Middleton-on-Sea Parish Council
7 North Avenue East
Middleton-on-Sea
Bognor Regis
West Sussex
PO22 6HQ

Construction of a crematorium comprising of a crematorium building & associated structures, car parking, access & landscaped spaces. This application is a Departure from the Development Plan.

Land south of the A259 Grevatt's Lane Climping

OBJECTION TO CM/4/19/PL

Title
PROPOSED SITE ACCESS
GENERAL ARRANGEMENT

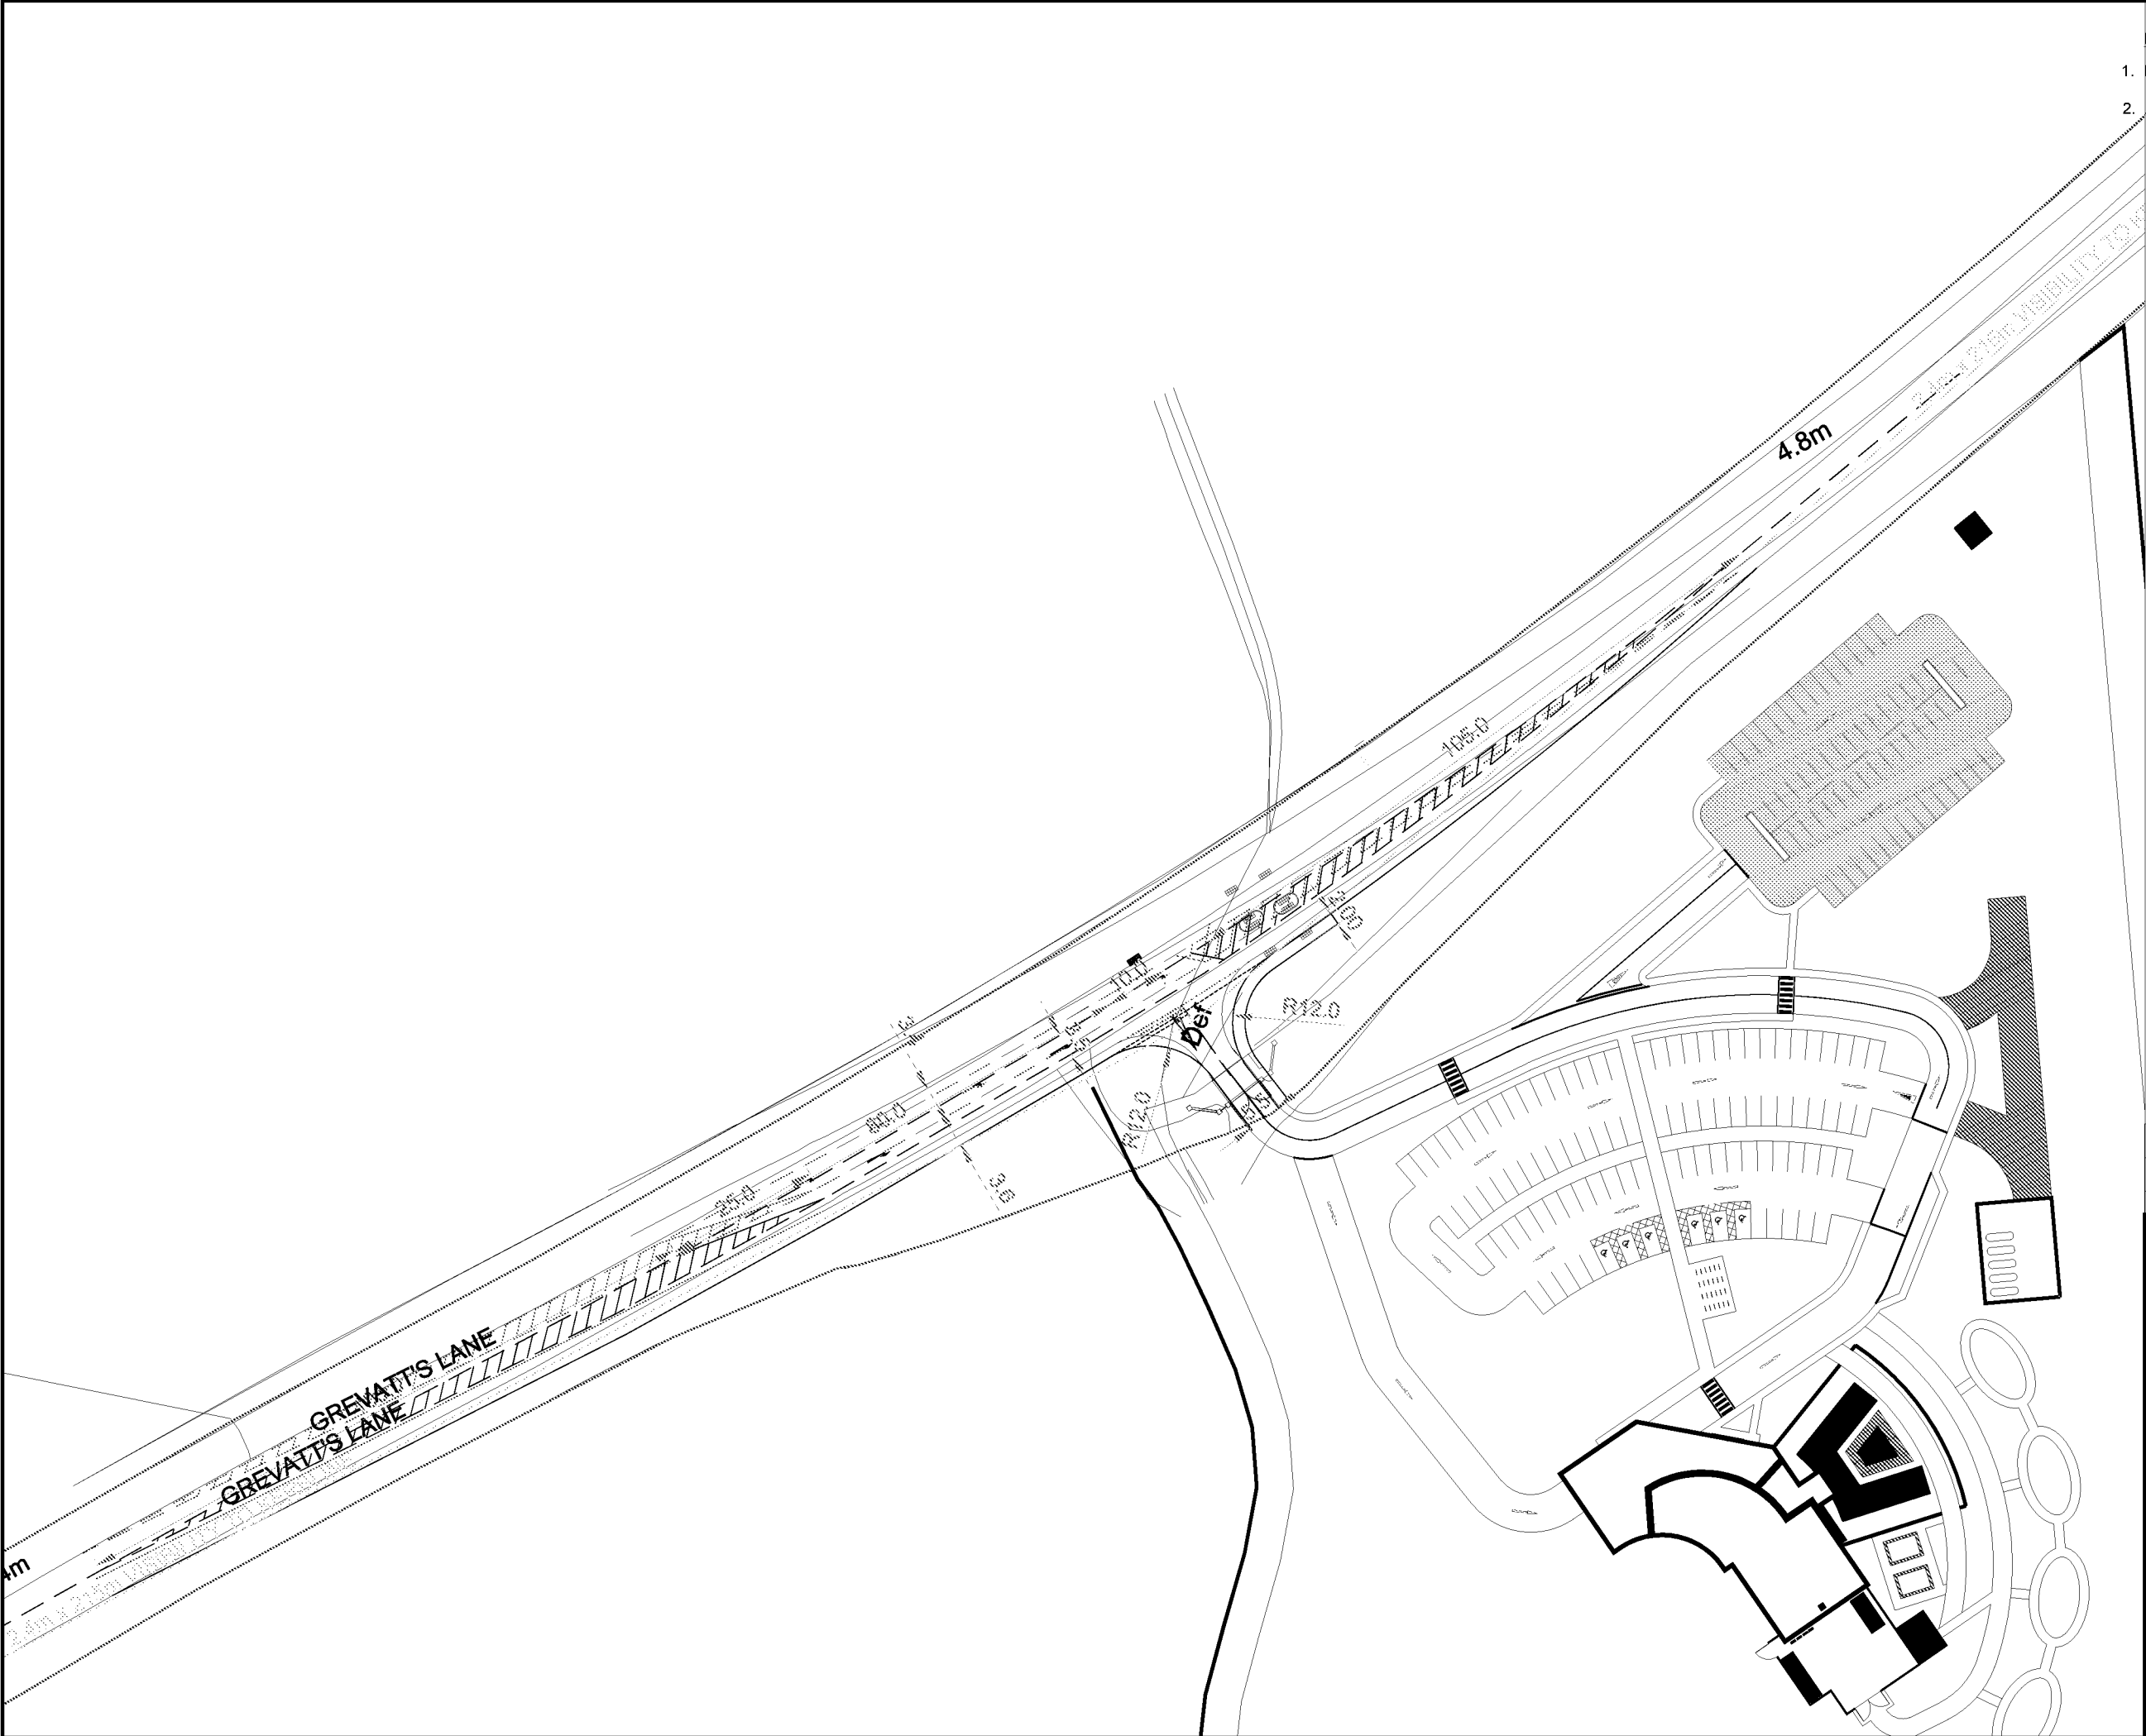
The proposed access to the crematorium is both dangerous and flawed because:

- The proposed junction is on an unlit section of the A259 with a 60 mph speed limit. Based on the Traffic Statement data, traffic is travelling along this section of at speeds*

generally in excess of 50 mph. With slow moving corteges regularly moving along this section of road, it will have an adverse impact on other motorists, particularly as the corteges slowly turn off the A259 to access the crematorium. This will undoubtedly increase the risk of accidents particularly on winter afternoons when light levels are low.

- It also needs to be borne in mind that there is a further junction on the same side of the road only some 300 yards to the east which is for access to an industrial park. This junction has been problematic for some time with slow moving lorries entering and leaving the site and has only recently been modified.

- When vehicles wish to leave the crematorium, they will tend to do so in groups and will all be trying to turn left or right on to the A259. The experience of Comet Corner and The Oystercatcher junctions are that it can be particularly difficult to turn right at any time of the day. Given the similarity of proposed new junction from the existing junctions it is reasonable to assume that if say 10 or 15 vehicles try to leave the crematorium at about the same time there will be peer pressure on the car at the junction to take a risk when pulling out. (Fatalities have occurred at both the Comet Corner and Oystercatcher junctions).
